**Comments on the Outline Surface Water Drainage Strategy  
for the  
Royal Society for the Protection of Birds**

**Submitted for Deadline 2**

**Application by Alternative Use Boston Projects Limited for an  
Order Granting Development Consent for the  
Boston Alternative Energy Facility**

**Planning Inspectorate Ref: EN010095**

**SURFACE WATER
DRAINAGE CATCHMENTS
FIGURE 13.1**

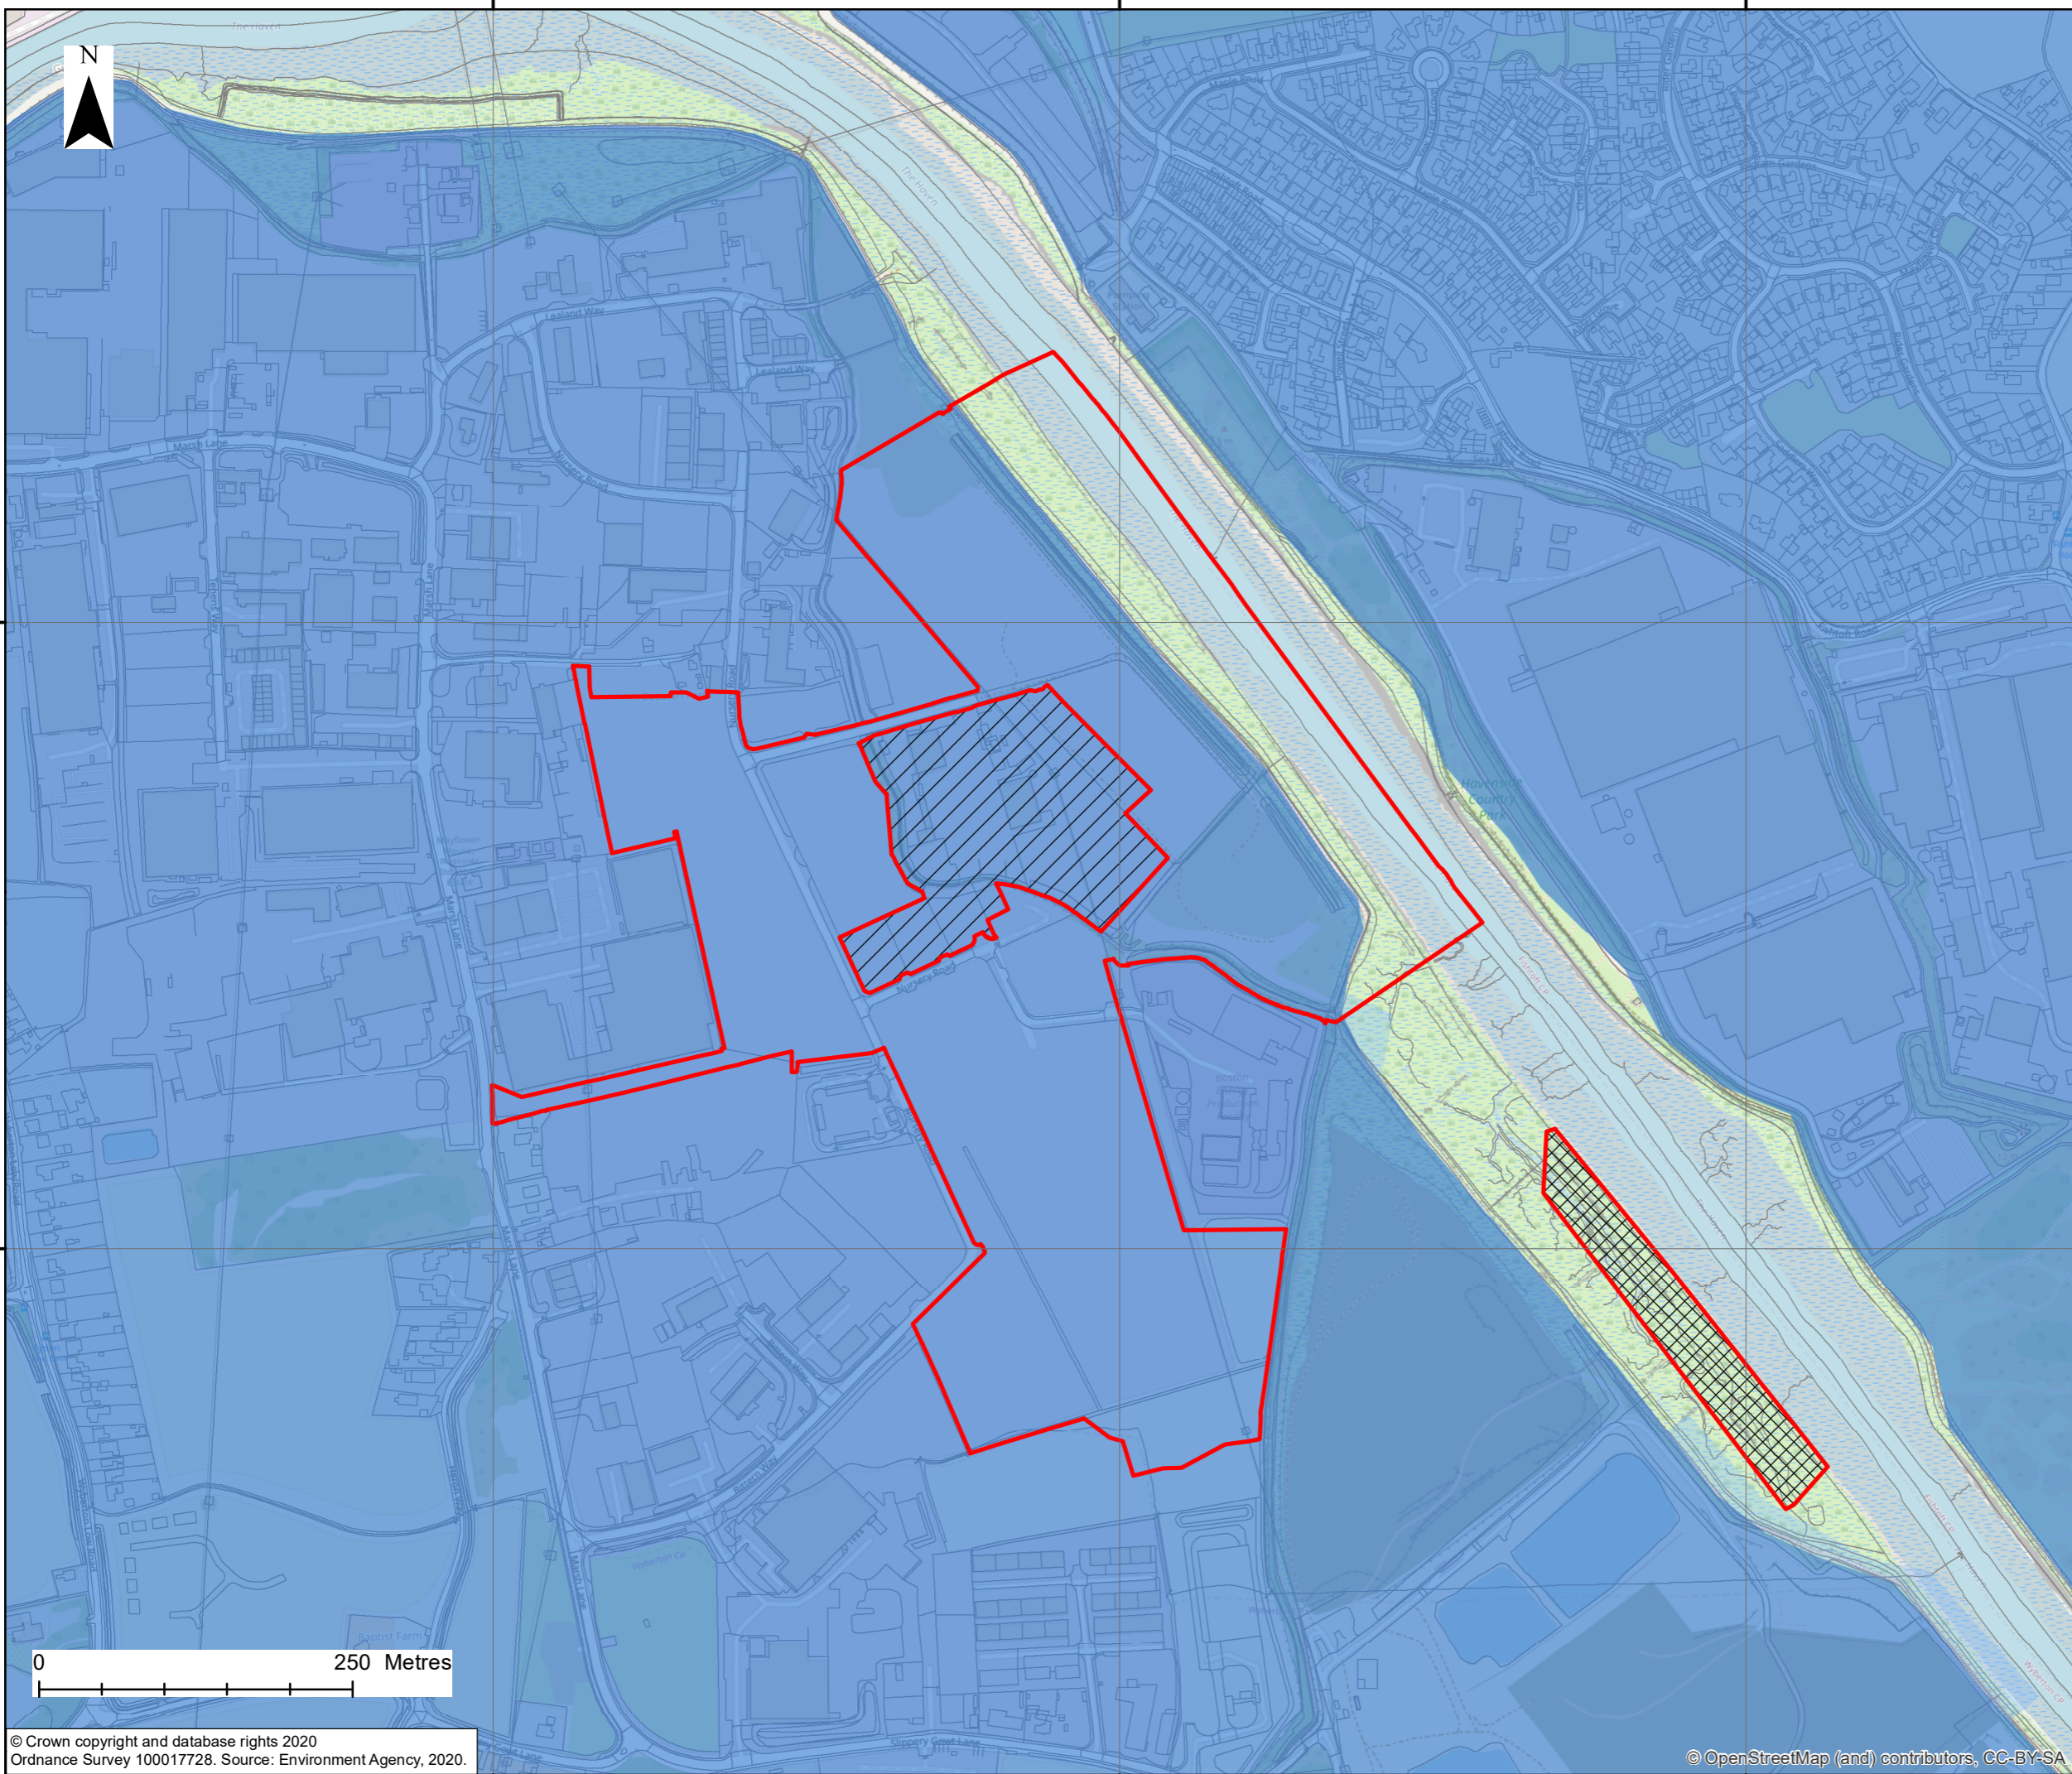
2	4.1.1	11	Whilst there is no direct discharge into the Haven, it does indirectly once water is discharged to the adjacent drainage network. The drainage network is operated via the IDB and water is automatically pumped into the Haven. This needs to be clarified in the drainage strategy.	Clarify that discharge to The Haven does occur via the drainage network and Wyberton Marsh pumping station.
